From: Philip Woolger [REDACTED]
Sent: 27 October 2020 12:34
To: Kathryn Welch <Kathryn.Welch@arun.gov.uk>
Subject: RE: 8 Fernhurst gardens.

From: "Kathryn Welch" <Kathryn.Welch@arun.gov.uk>
To: "Philip Woolger" [REDACTED]
Sent: Tuesday, 27 Oct, 20 At 10:51
Subject: RE: 8 Fernhurst gardens.

Drawing No.010
Date 27/09/20
Issue 02 NTS.
Dimensions And
Garage added

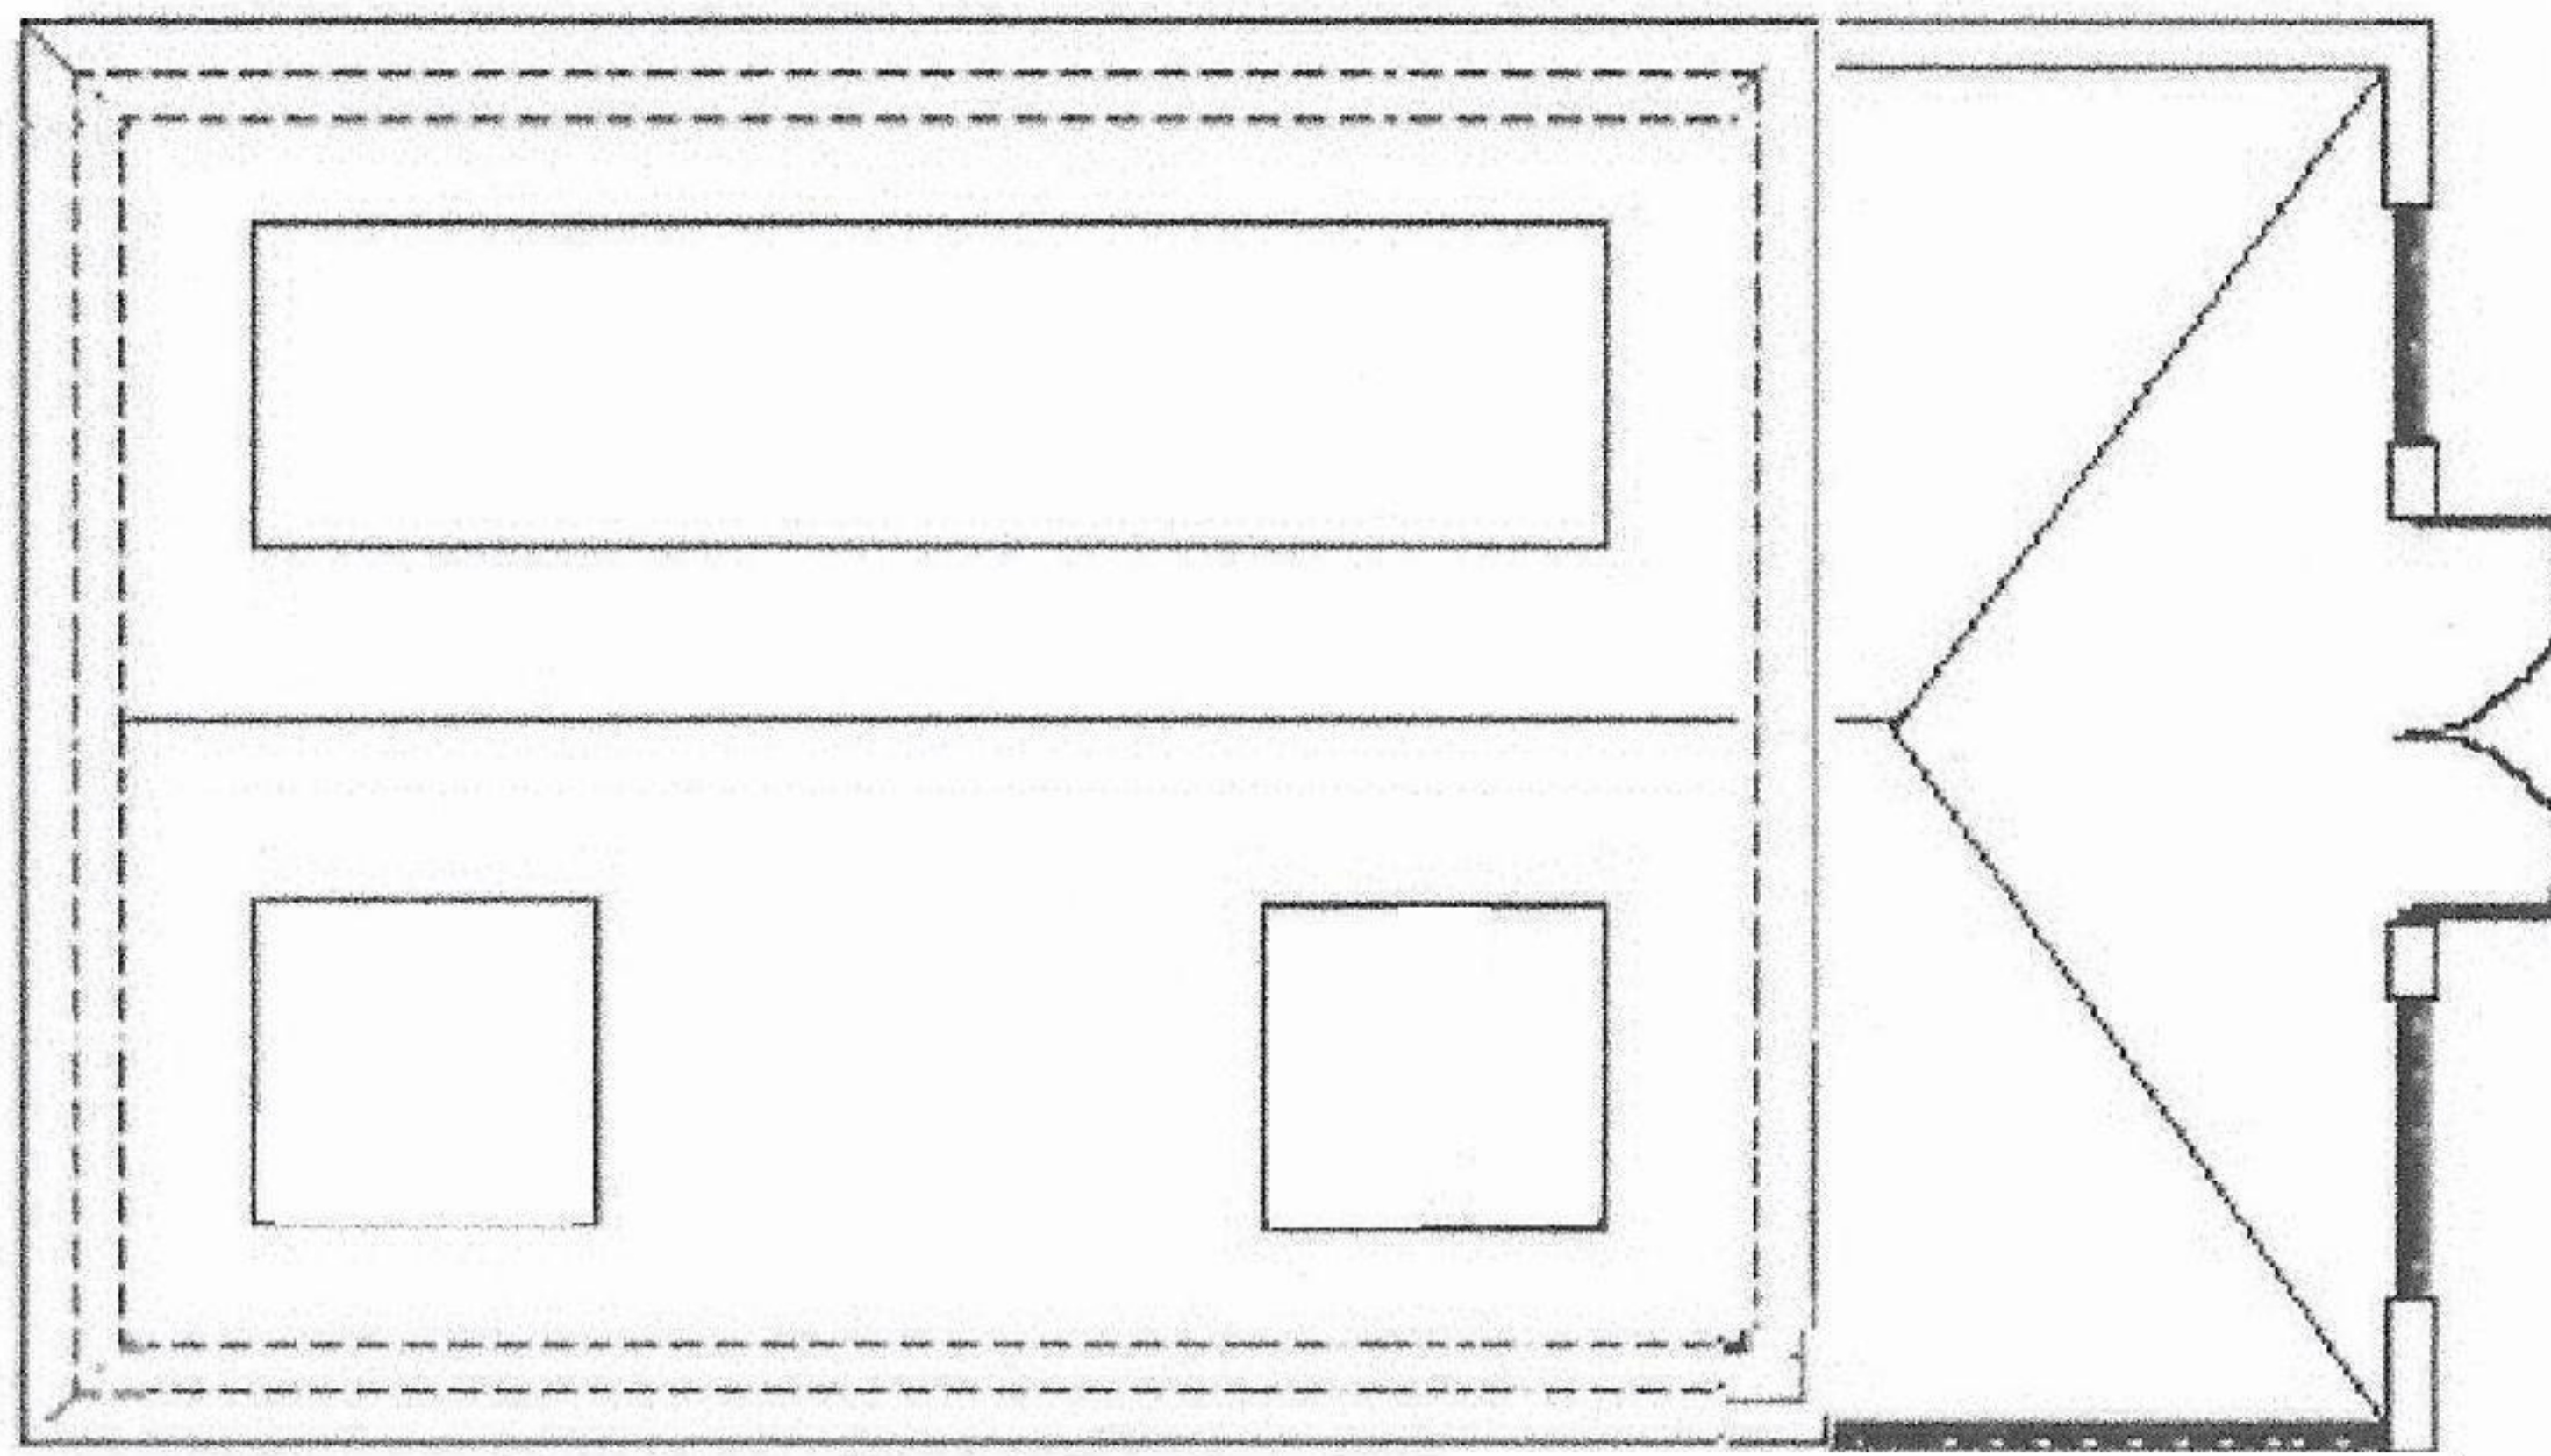
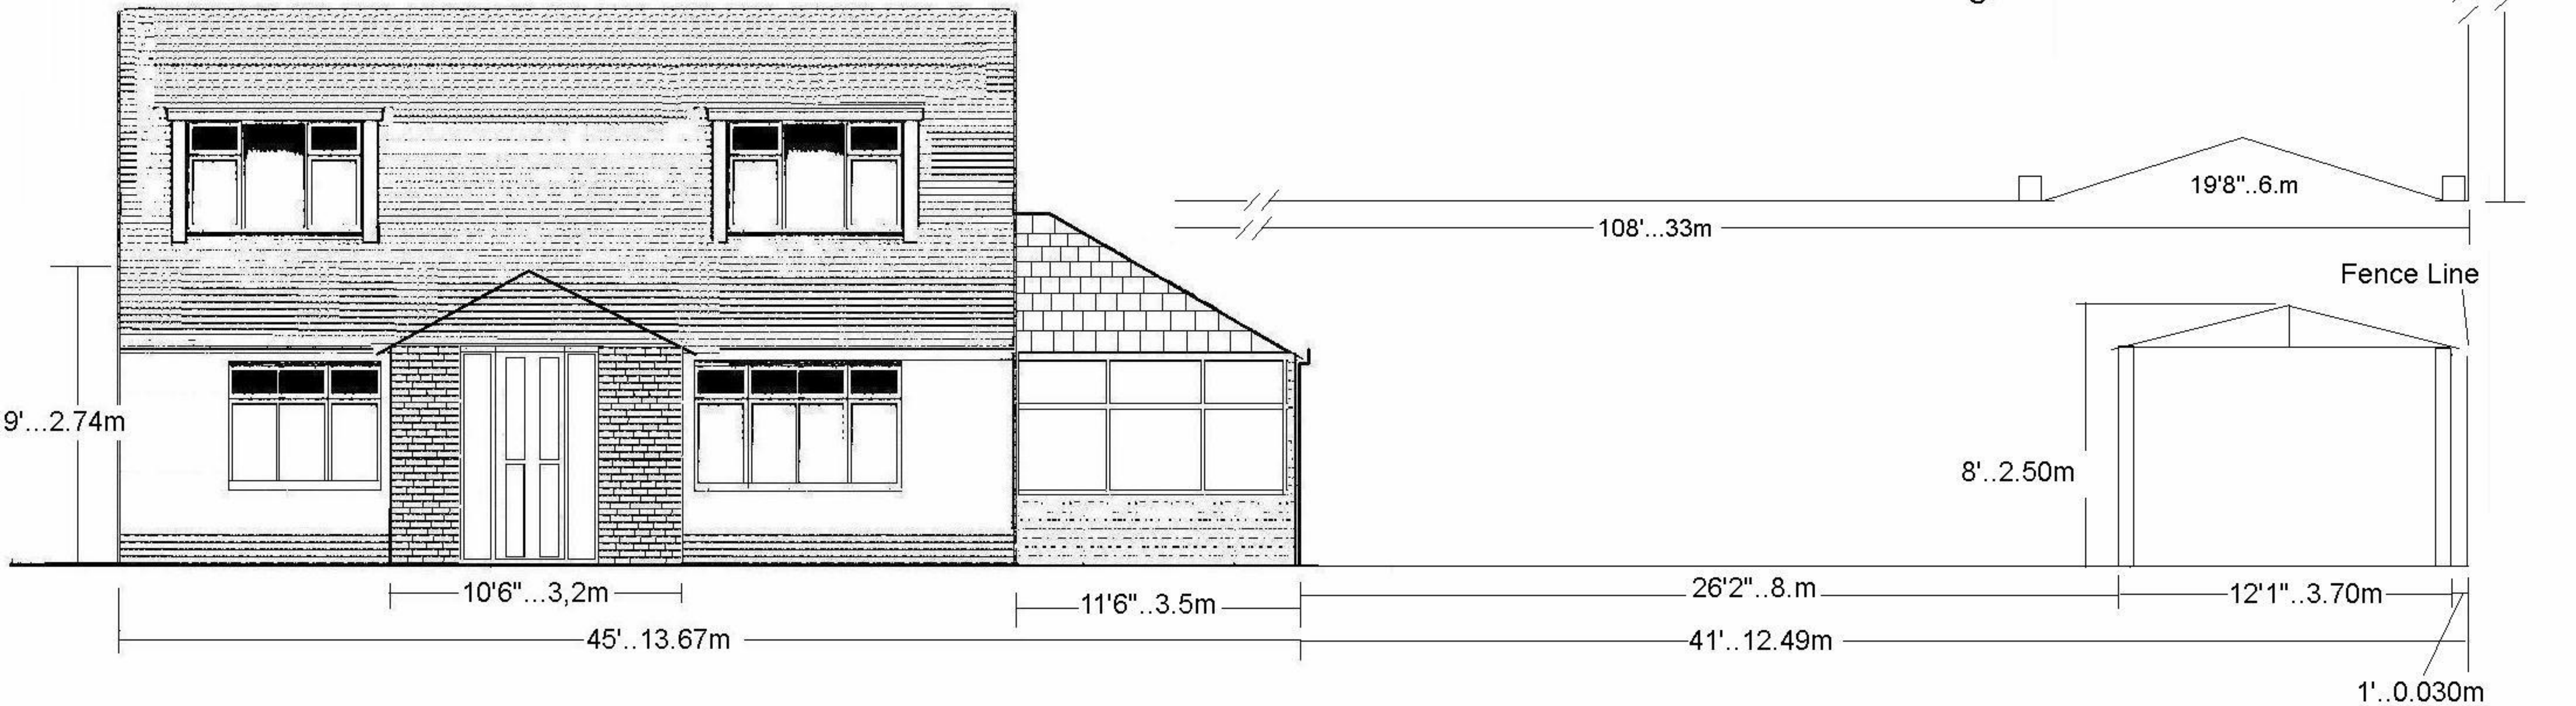
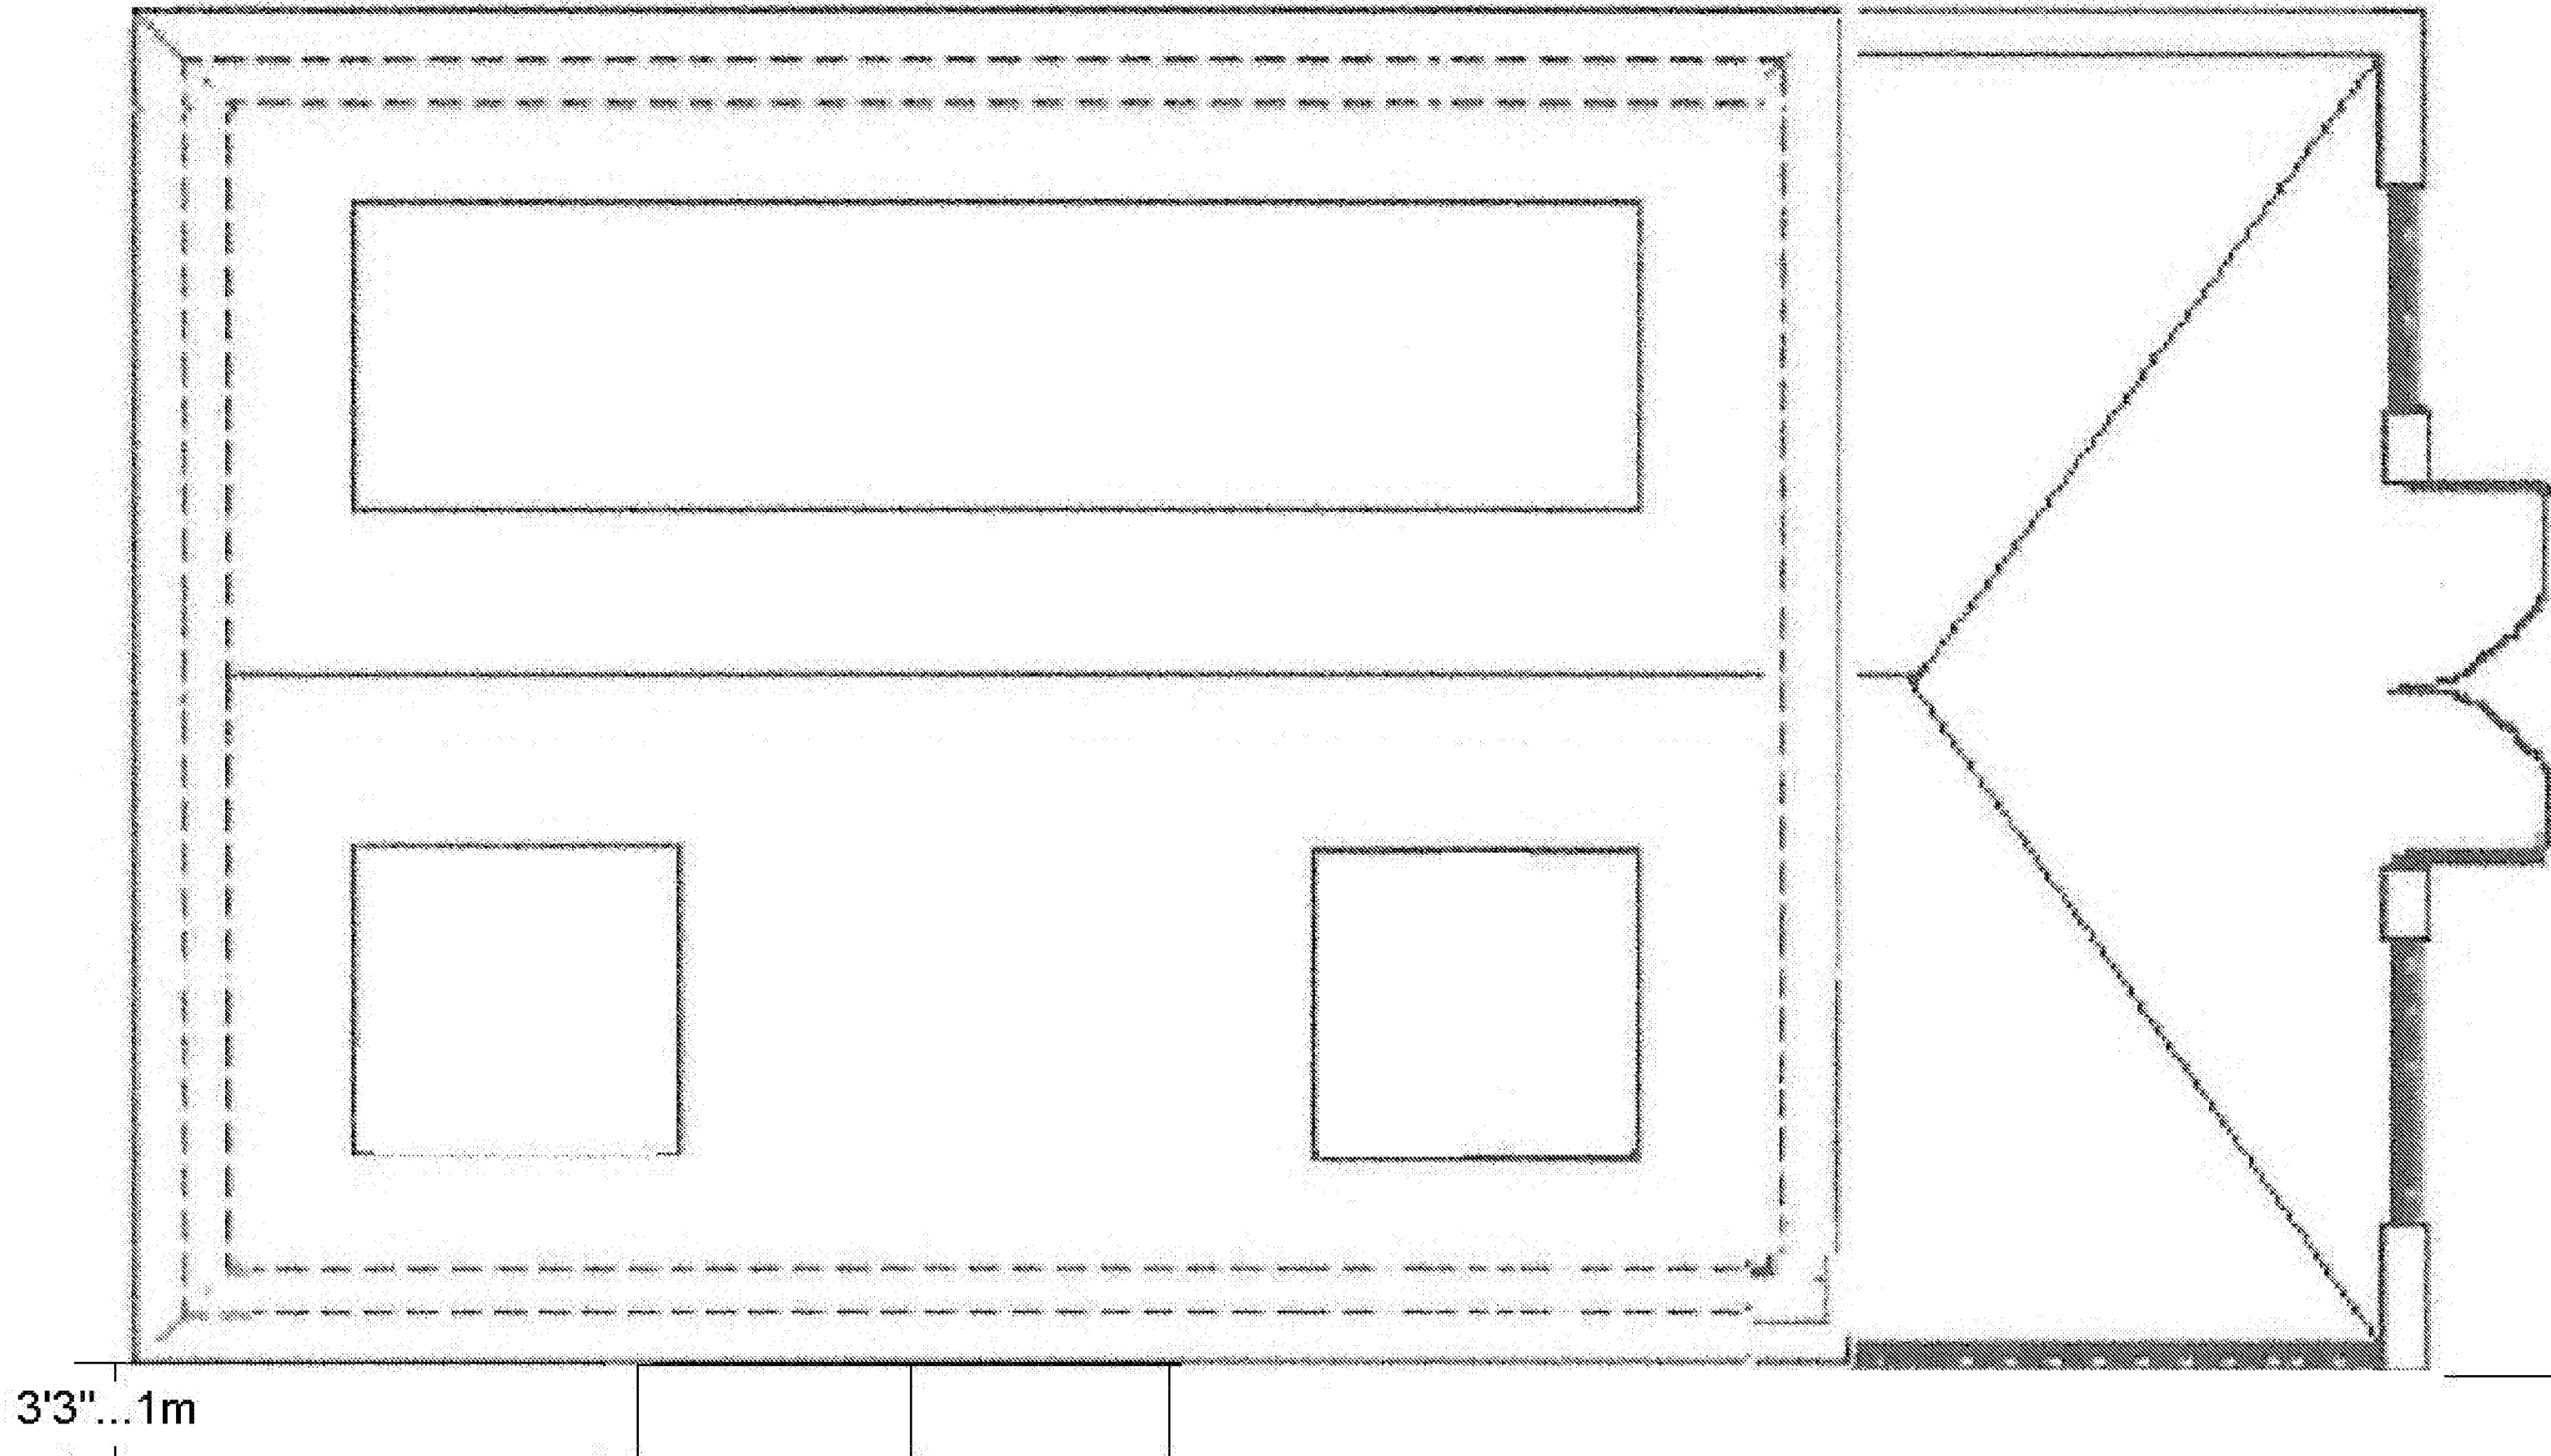
- The porch is slightly too large, to be covered by PD rights the maximum allowance is 3m² and your proposal currently measures at 3.84m² can you adjust this on plans 010 and 003.
- Can I have confirmation of the height to the eaves for the extension, either via email or included within a plan,
- Can you confirm that the extensions will be built of materials to match the existing property. You've noted a concrete slate tile on the roof of the extension; do you already have these on the existing house or can you amend to something similar to the existing,
- Can you confirm the proposed hardstanding for 2-3 cars will be built of either porous materials or will drain off to water permeable area within the site, again just a written confirmation will suffice.

porch 3m x 1m ...2.2m to eaves.....Antique red Marley plain tile 265 x 165mm as per existing building.....and Block paved driveway (we were planning on this)just missed it off. We understand about the drain off on solid concrete.

Attached drawing 003...and 010...adjusted .
